Harnett County Government Complex
307 Cornelius Harnett Boulevard
Lillington, NC 27546

Woodshire

Re: Status of Improvement Permit Application #08-5-19958 Lt 166
#08-5-19957 Lt 180

On May 6, 2008, an attempt was made to evaluate your property for the purpose of issuing an Improvement Permit. The evaluation could not be completed for one or more of the following reasons.

SURVEY FOR:
PROPOSED PLOT PLAN - LOT - 166
WOODSHIRE S/D, PHASE FIVE

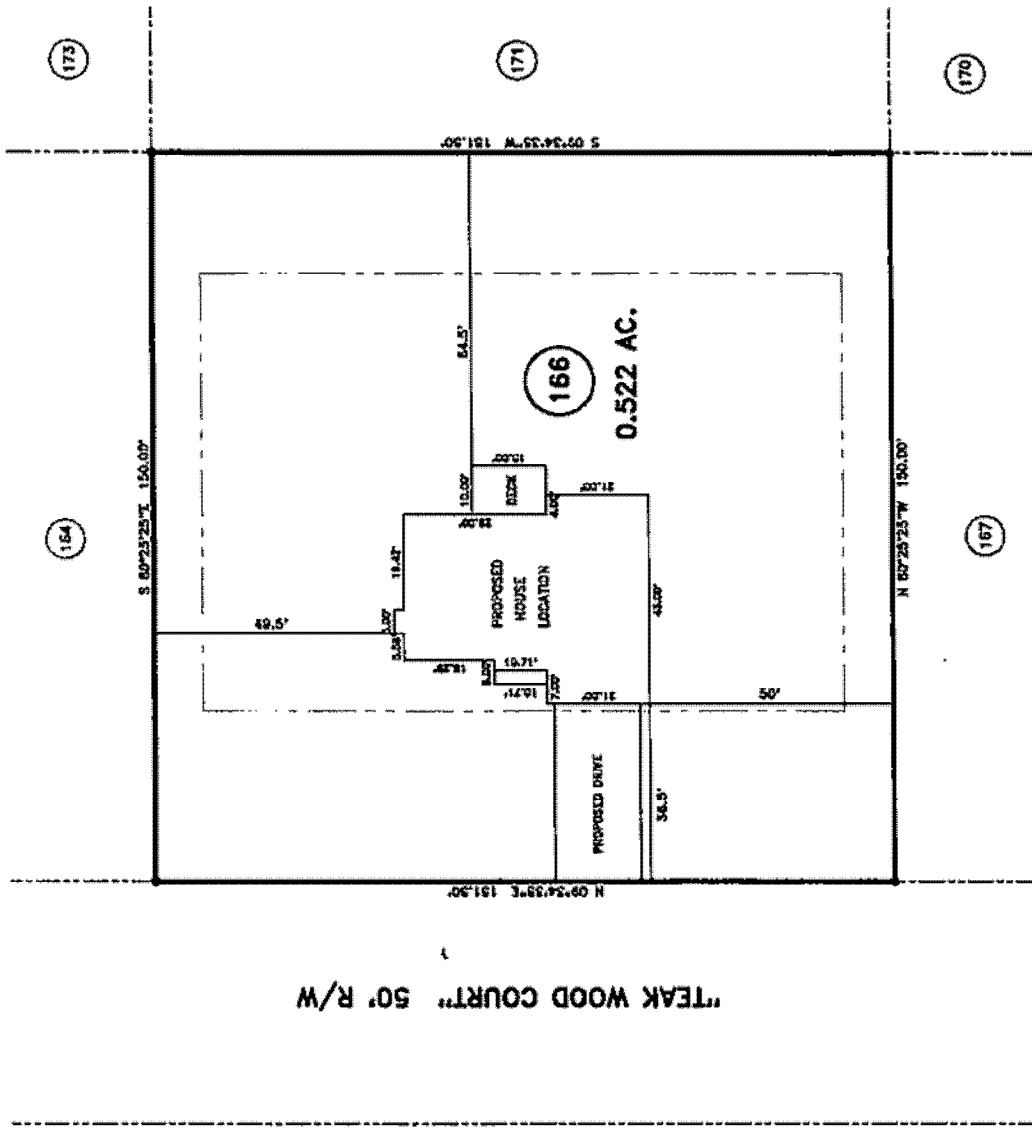
- 1. Property lines/corners not marked or labeled
- 2. House corners not marked or labeled
- 3. Directions not clear to property
- 4. Property needs brush or vegetation removed
- 5. Backhoe pits required
- 6. Other – Make changes as noted and submit new plot plan to Central Permitting.

Move house
And
Driveway
As show
